Our ref: DOC20/210768-9

Your ref: SSD-10378

Mixed-use Development, 42 Honeysuckle Drive, Newcastle (SSD-10378) – Review of Environmental Impact Statement

BCD has reviewed the *'Environmental Impact Statement: Construction of a Mixed Use Development, Including Commercial / Retail Uses and Hotel Accommodation – 42 Honeysuckle Drive, Newcastle NSW 2300'* (prepared by KDC Pty Ltd and dated February 2020), including relevant appendices, annexures and attachments in relation to impacts on biodiversity, Aboriginal Cultural Heritage and flooding.

Figure 5.2
Structural drawing of foundation plan for the development.
Bates
Smart
Foundation
Plan No.
S01.01
(October
2017).

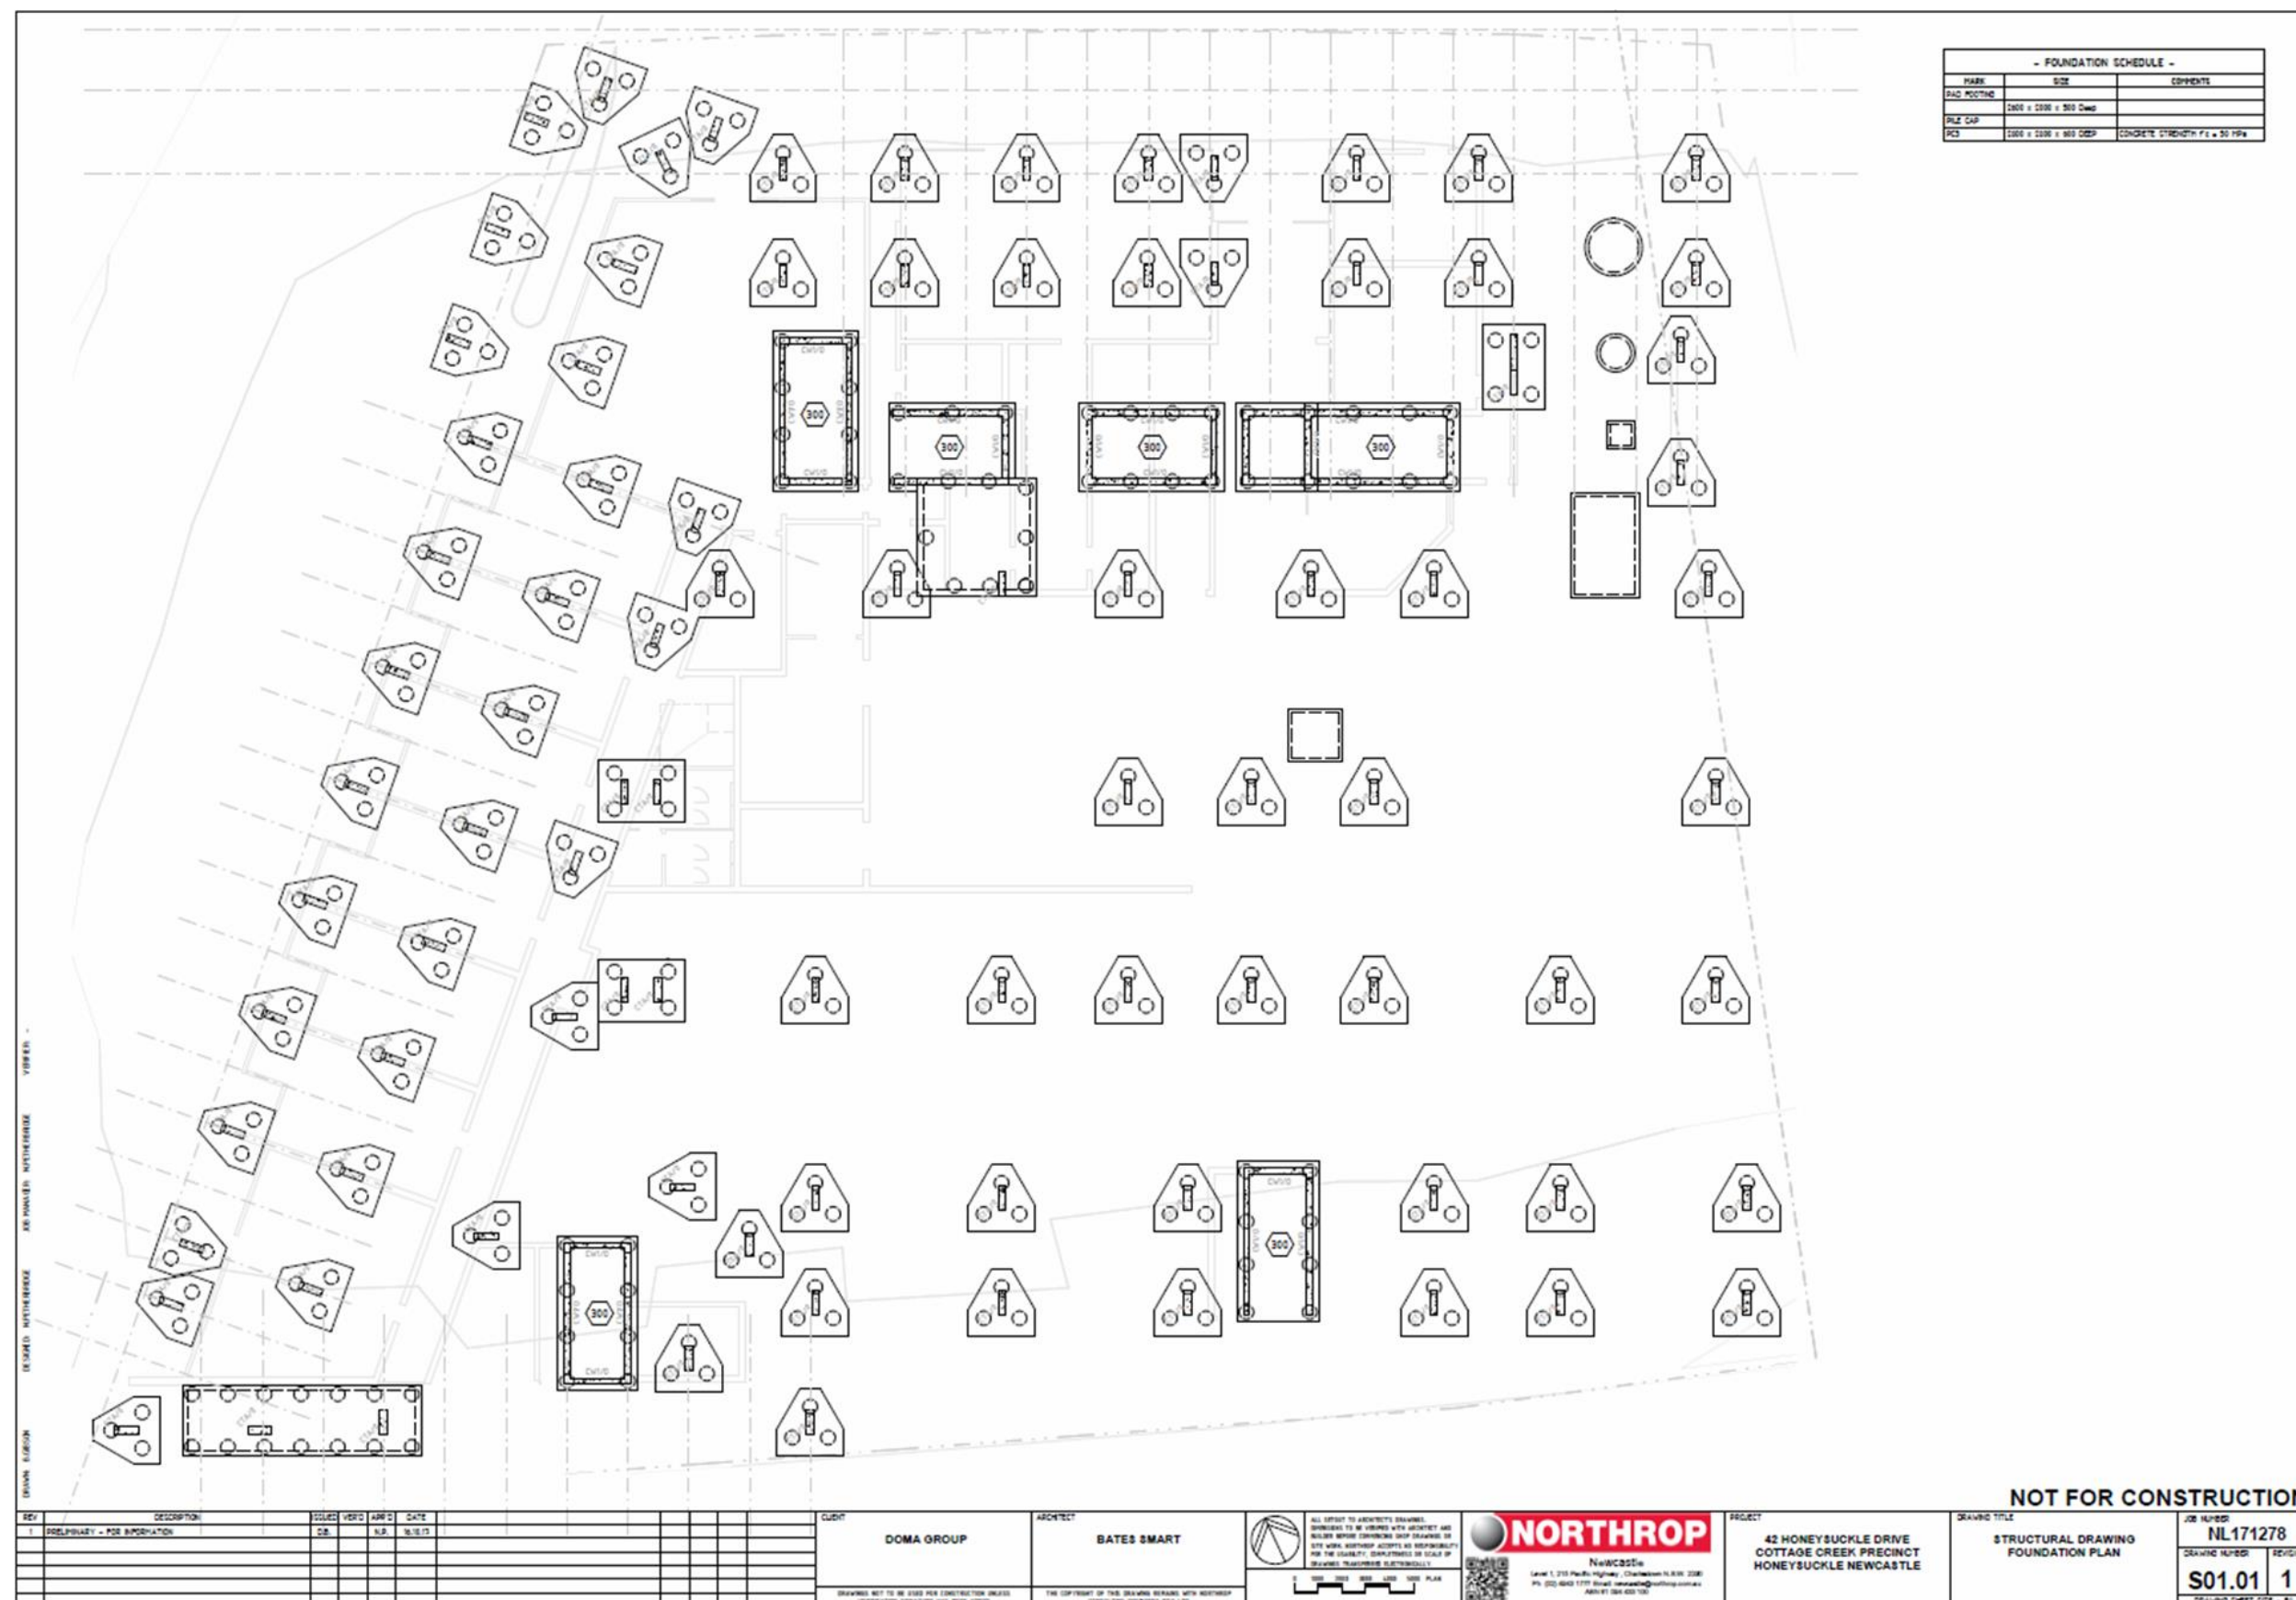
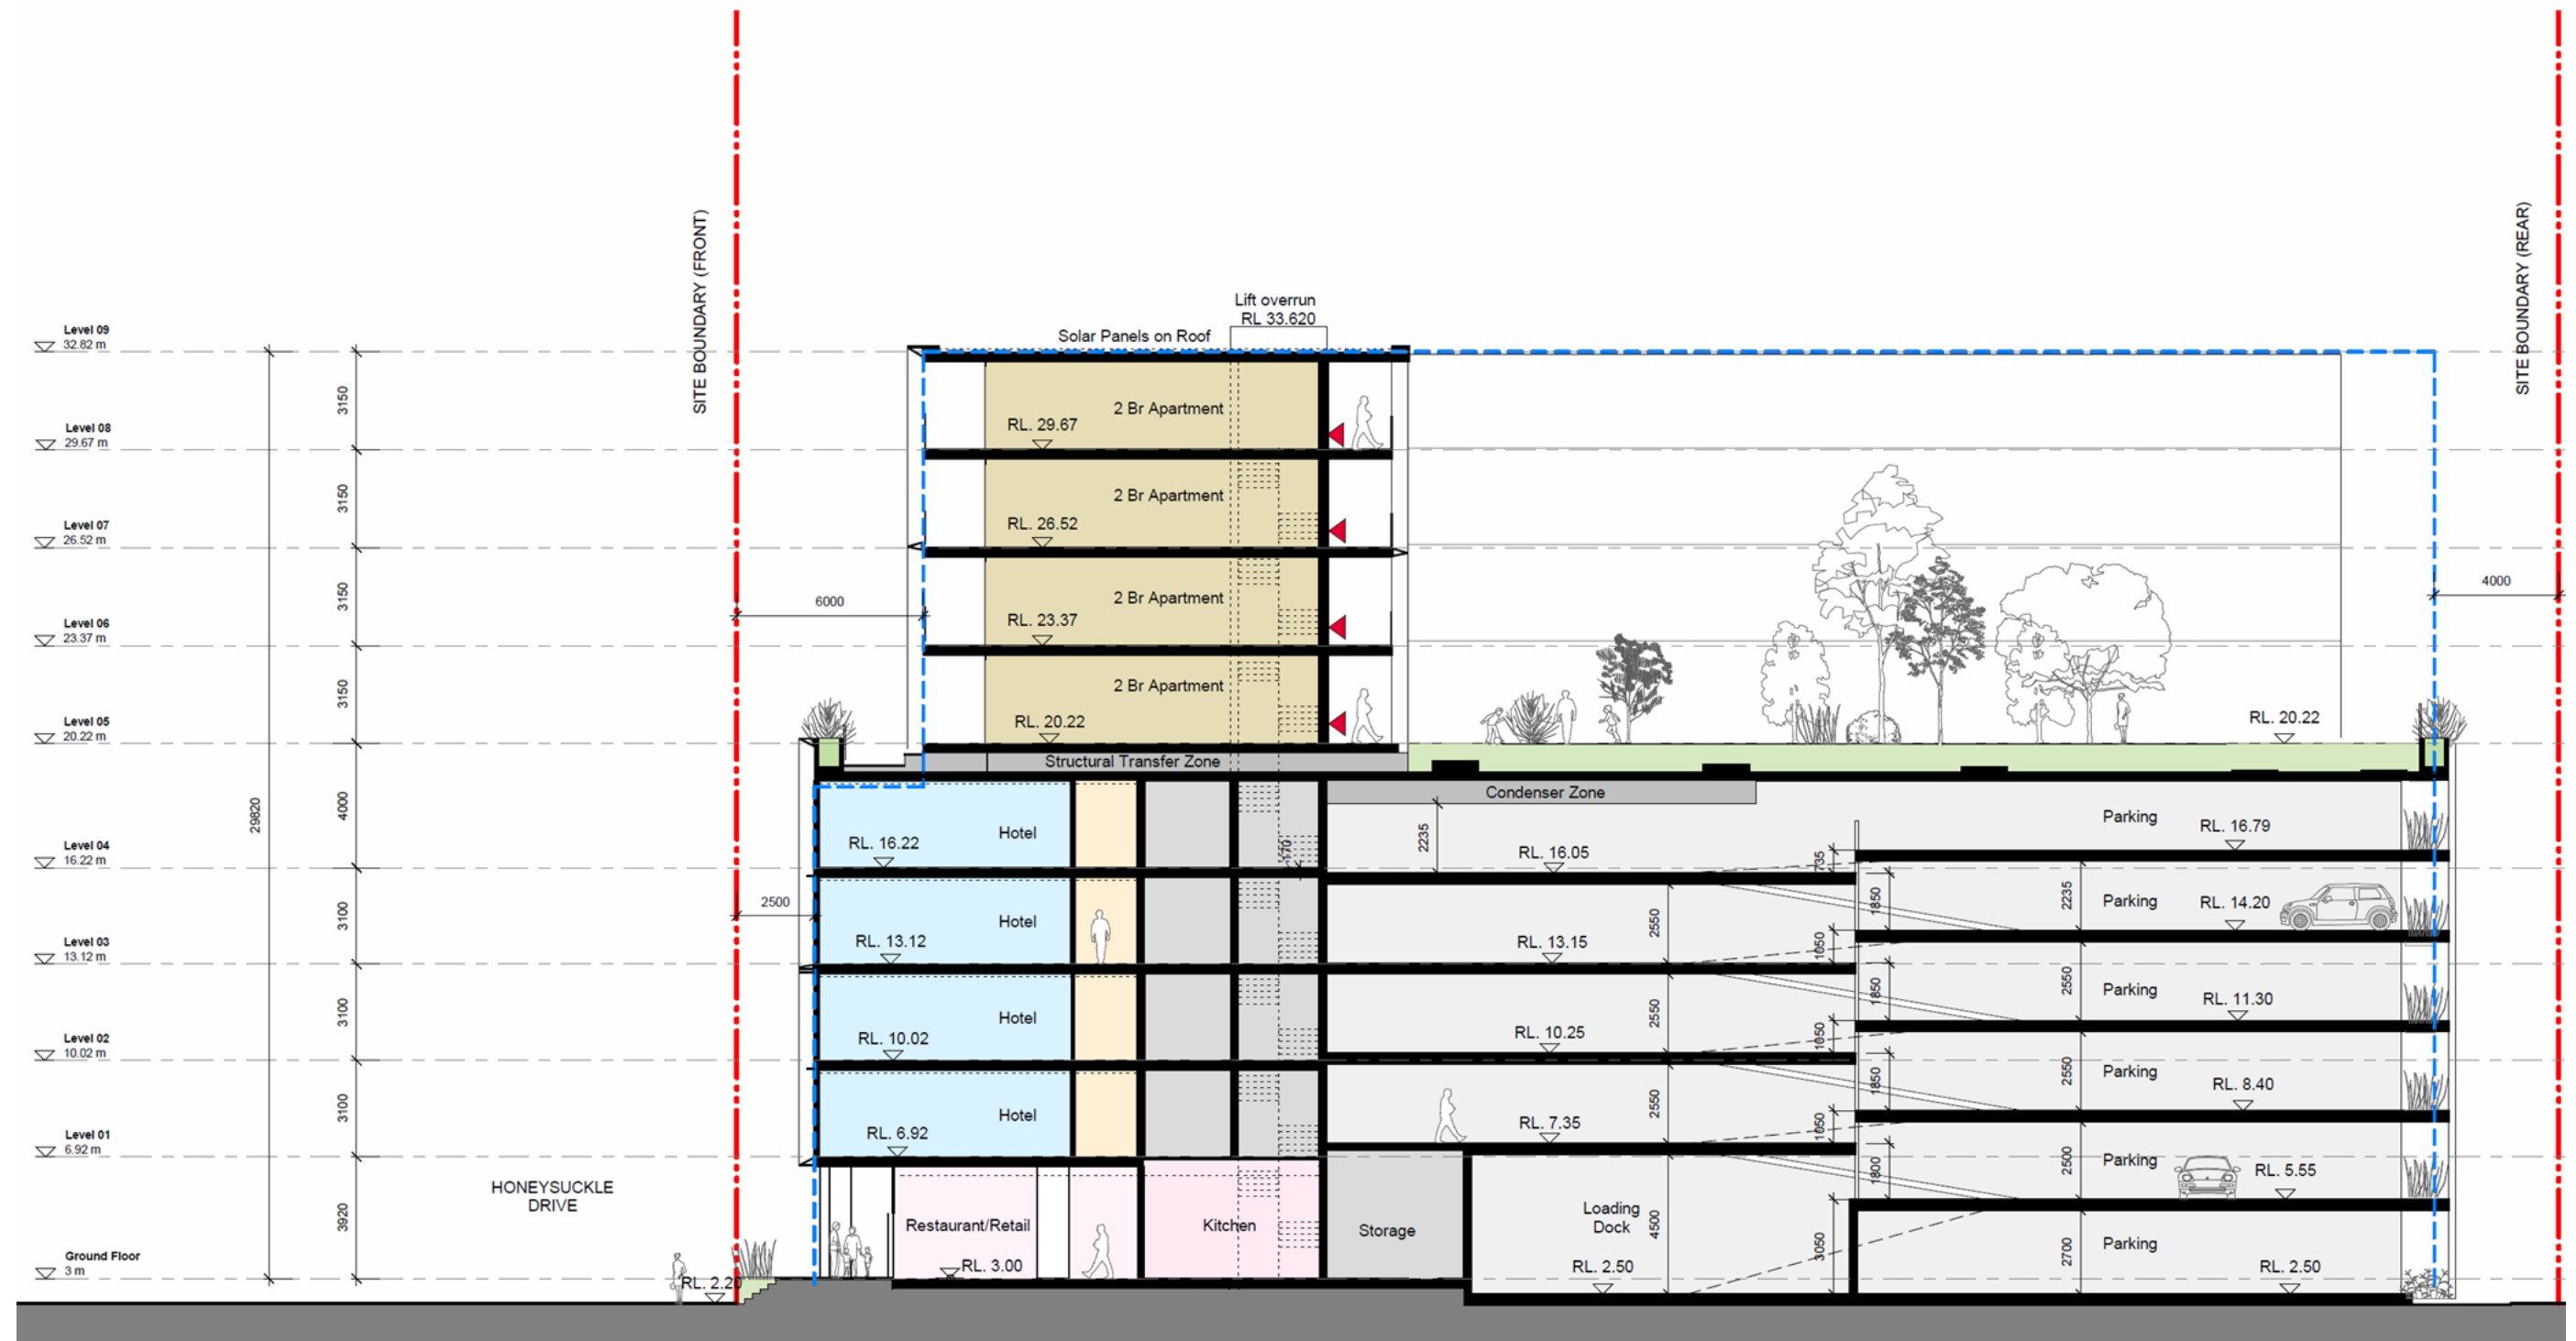
The EIS for the current SSD application (SSD 10378) refers to additional earthworks being required which include, but are not limited to, six new piles, capping and step-downs. Details of the location and extent of these earthworks have not been provided.

It is not clear whether the extent and depth of the development footprint for the current SSD application (SSD 10378) exceeds that of the previously approved SSD area (SSD 8840).

BCD recommends that the extent and depth of the development footprint for the SSD 10378 application area be provided and includes a comparison of the development footprint of the current and previous projects.
